From: Laura Gibbons
Sent: 20 February 2019 15:04
To: Planning.Responses
Cc: Amber Willard
Subject: RE: Planning Consultation on: EG/14/19/HH

Engineers Comments Regarding Surface Water Drainage

APPLICATION EG/14/19/HH

Description of Works: Single storey rear extension. A flat roof extension with two glazed lanterns. Two rooms one as a large living room to garden and the other as study.

PROPOSED EXTENSION
MR & MRS DOWD
2 UPTON BROOKS
BARNHAM
WEST SUSSEX
PO22 0DH
DEA NO PD/1218/PA/04 A
SCALE 1:50
AMENDED 02/19

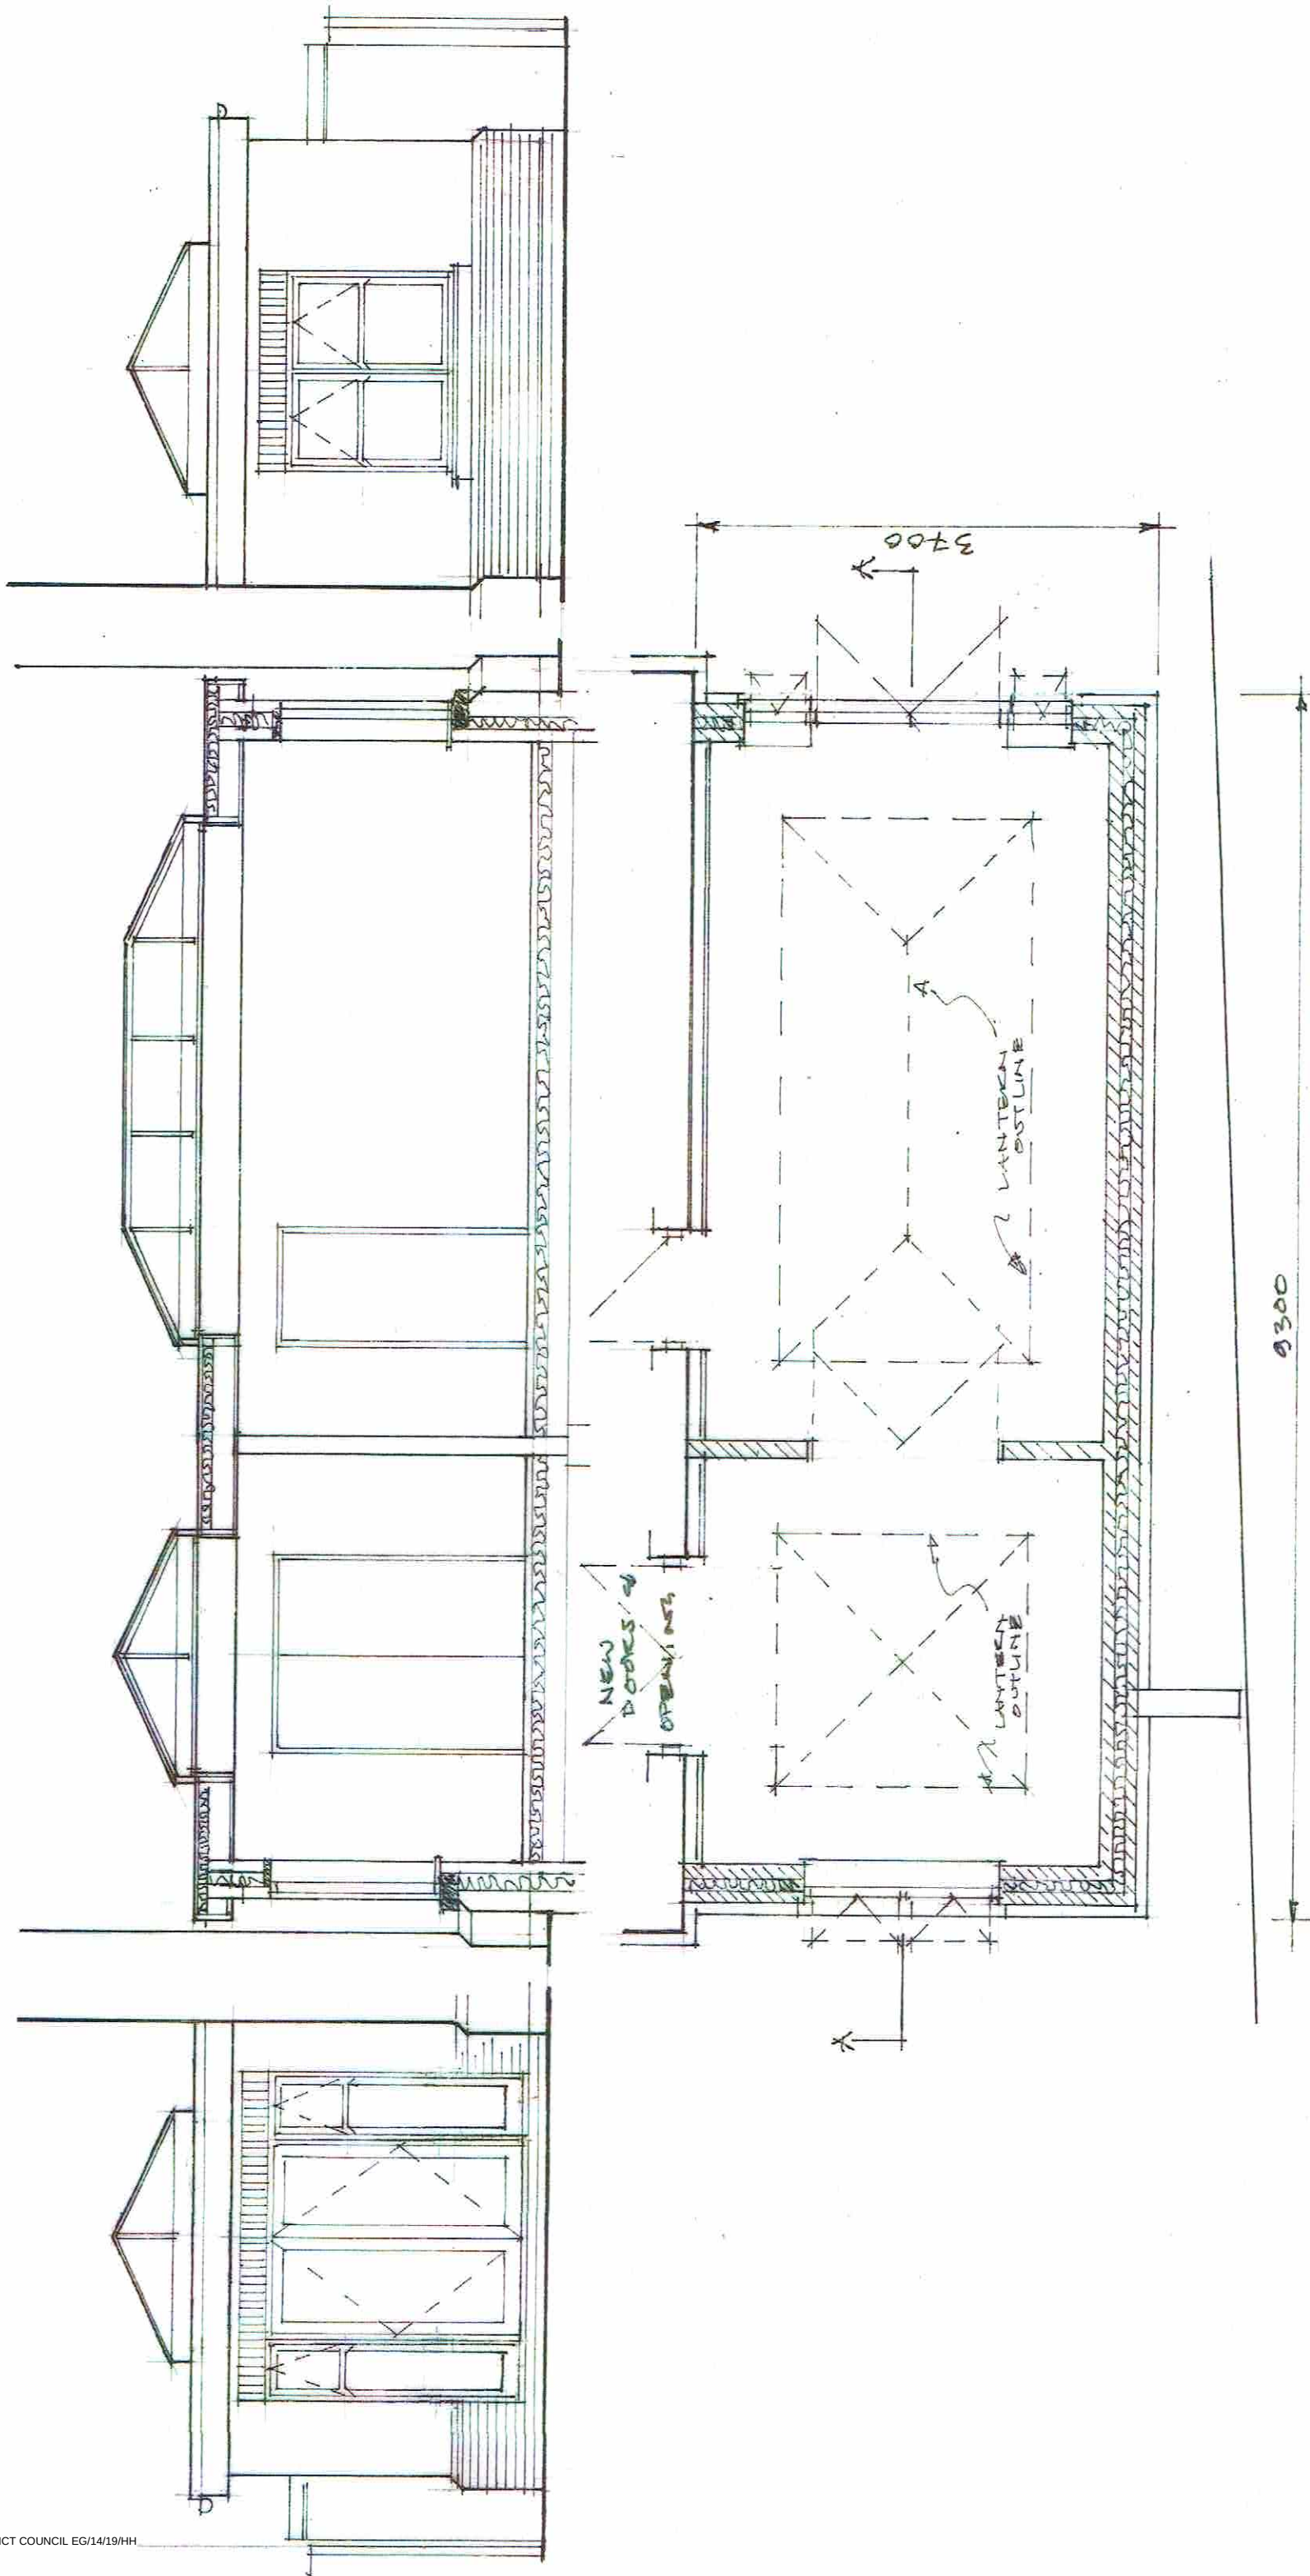
It should be noted that a land drain is present directly in line with the proposed extension, however it is unknown if the land drain extends this far north. Should the application be approved and a land drain be found on site the applicant should contact us.

Infiltration must be investigated.

Infiltration rates for soakage structures are to be based on percolation tests undertaken in the winter period and at the location and depth of the proposed structures. The percolation tests must be carried out in accordance with BRE 365, CIRIA R156 or a similar approved method and cater for the 1 in 10 year storm between the invert of the entry pipe to the soakaway, and the base of the structure. It must also have provision to ensure that there is capacity in the system to contain below ground level the 1 in 100 year event plus 40% on stored volumes, as an allowance for climate change. Adequate freeboard must be provided between the base of the soakaway structure and the highest recorded annual groundwater level identified in that location.

Any SuDS or soakaway design must include adequate groundwater monitoring data to determine the highest winter groundwater table in support of the design. The applicant is advised to discuss the extent of groundwater monitoring with the Council's Engineers. Supplementary guidance notes and our surface water drainage submissions checklist are also enclosed for information.
